OBSERVATION/SUBMISSION TO PLANNING APPLICATION

Case Reference: 323761

Re: Observation/Submission to proposed wind energy development at Cooloo Wind Farm

Applicant: Neoen Renewables Ireland Limited

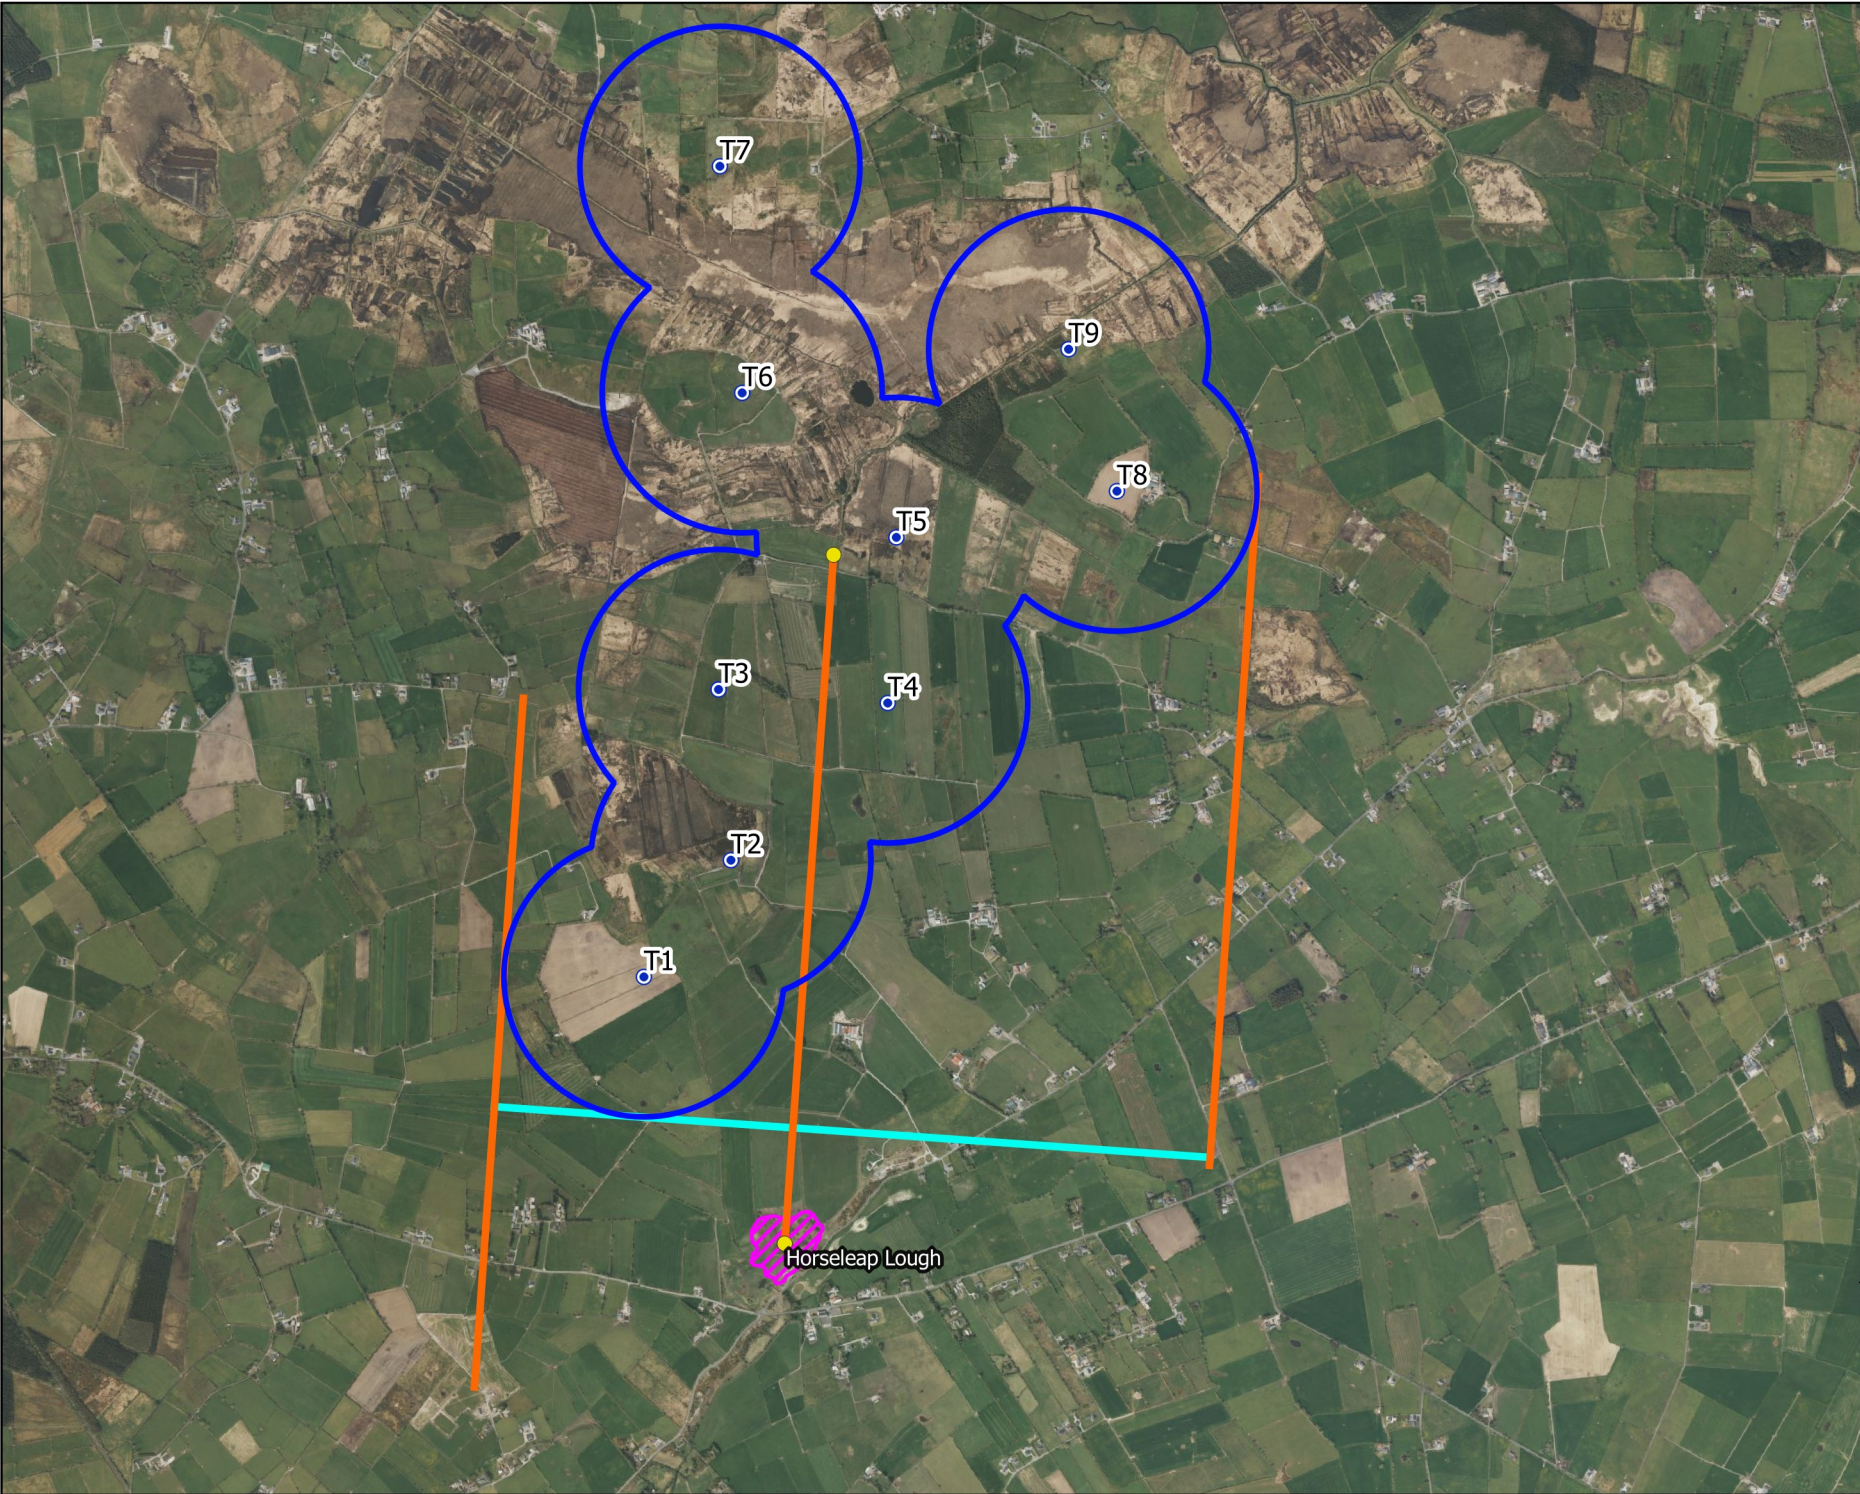
I object to the proposed development on the grounds that the Collision Risk Assessment (Appendix 7-6, MKO 2025) is methodologically and scientifically inadequate to protect legally protected bird species.

The assessment relies on the theoretical Band Model, which assumes fixed avoidance rates and static behaviour, without validation using telemetry or local field data. Survey coverage is temporally and spatially limited, missing key migration and nocturnal flight periods. This approach fails to capture the real-world behaviour of birds in the area.

The use of a 99.5% avoidance rate for Whooper Swans, without local validation, significantly underestimates the risk of collision. Evidence from Irish Wetlands Bird Survey (I-WeBS) and BirdWatch Ireland indicates that Whooper Swans routinely commute between Horseleap Lough and surrounding feeding areas at low altitudes that overlap turbine rotor heights. The conclusion of 'negligible risk' is therefore unsupported and unreliable.

Mitigation measures are undefined and untested. Key figures such as flightline maps (e.g., Figure 7-6-1) are omitted, hindering independent review and transparency. Without clear, evidence-based mitigation strategies, there is no guarantee that collision risks can be managed effectively.
